**Addendum No. 1**

RE: Contract # C203778

**Wilson County (I-5727, I-5842)**

I-95 From SR-1116 (Governor Hunt Road) To SR-1309 (Bloomery Road)

PROJECT NO.			SHEET NO.	TOTAL NO.
I-5727	-	52005.3.1 - NHPP-0095(22)124	3	
I-5842	-	53048.3.1 - NHPP-0095(26)125

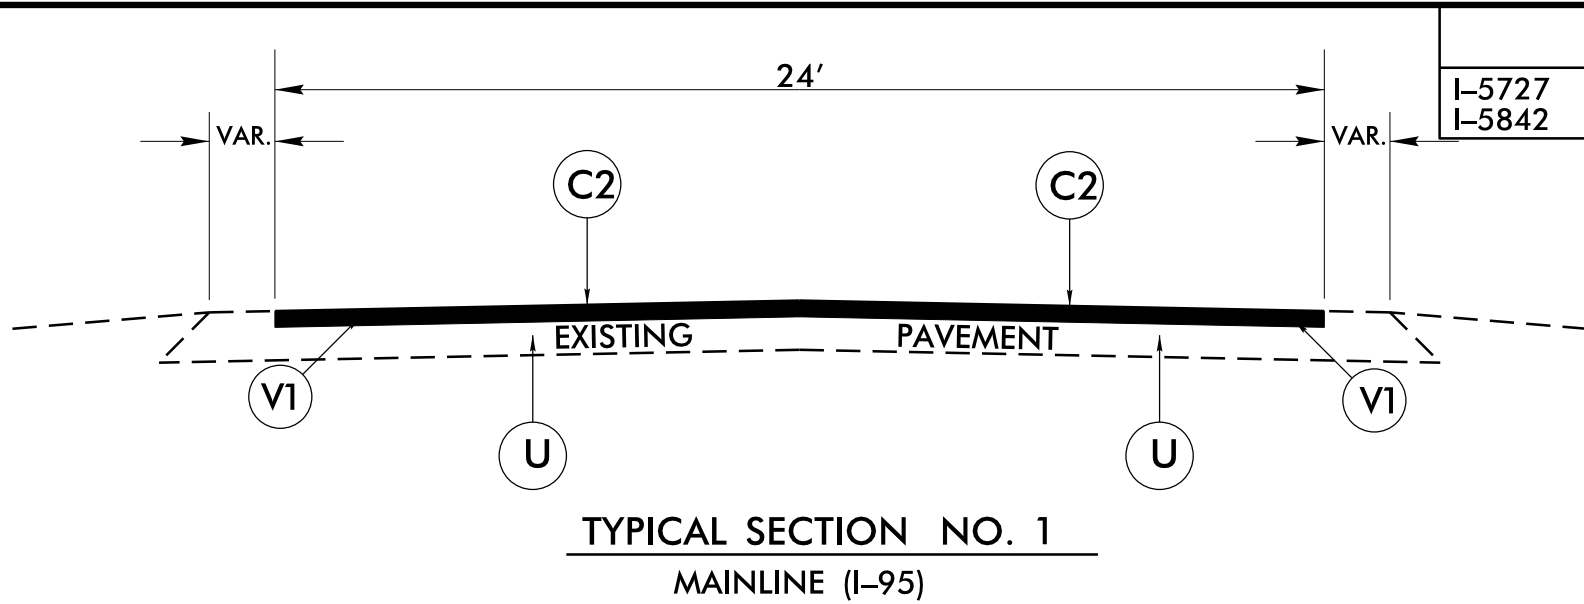
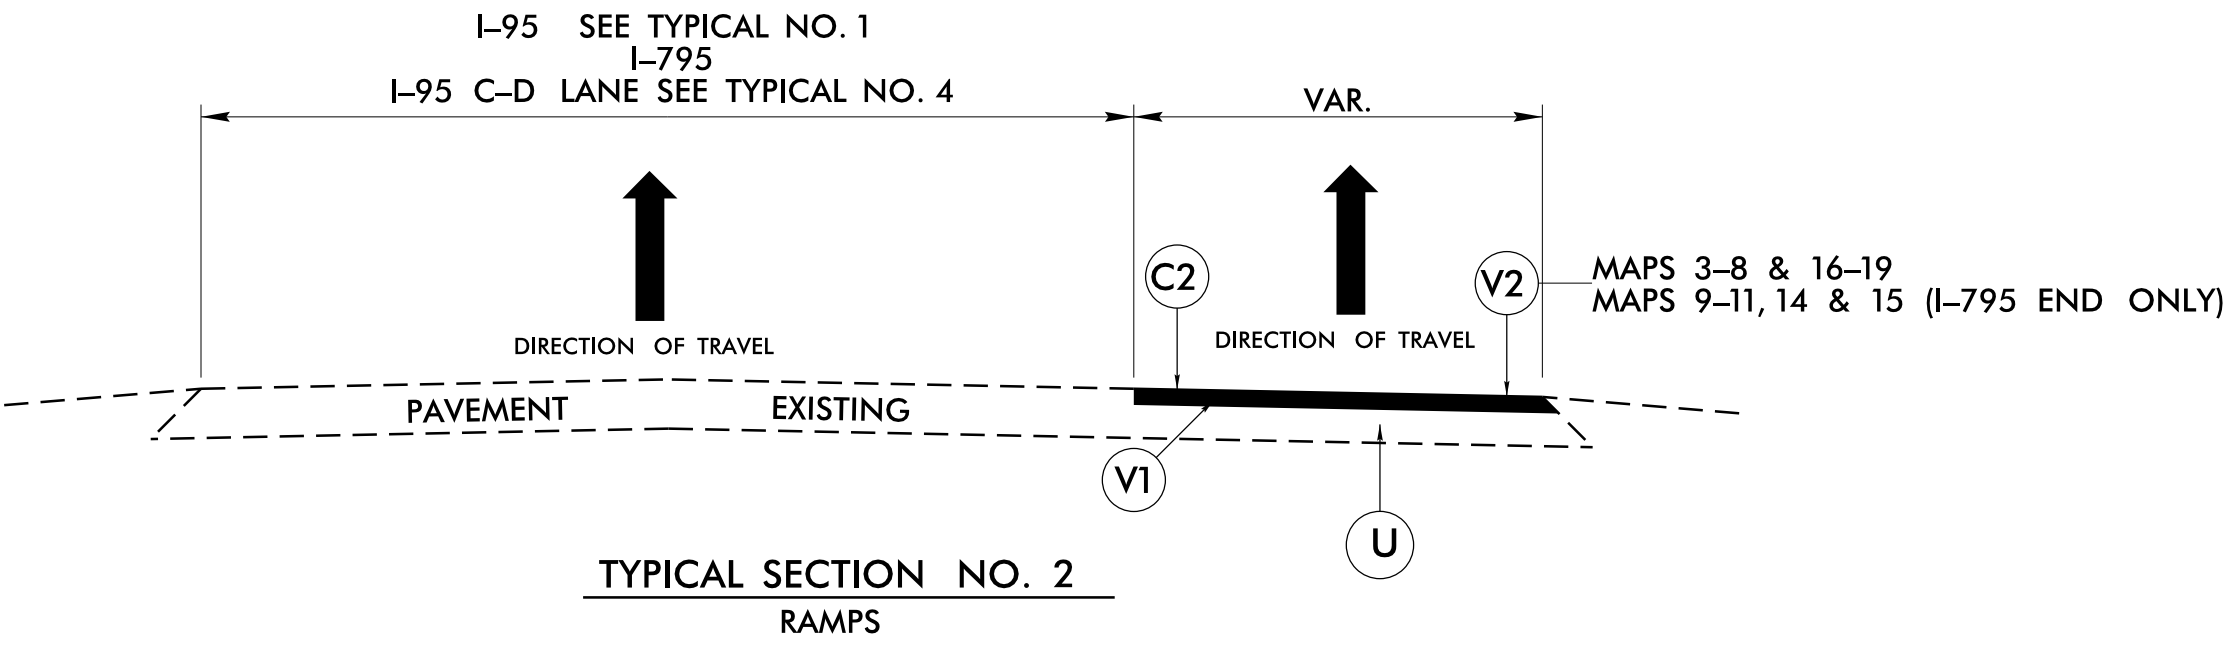
Sheet No.	Revisions
2 thru 4 and 6 thru 11	Revised to reflect the below noted pay item addition, deletion and quantity changes
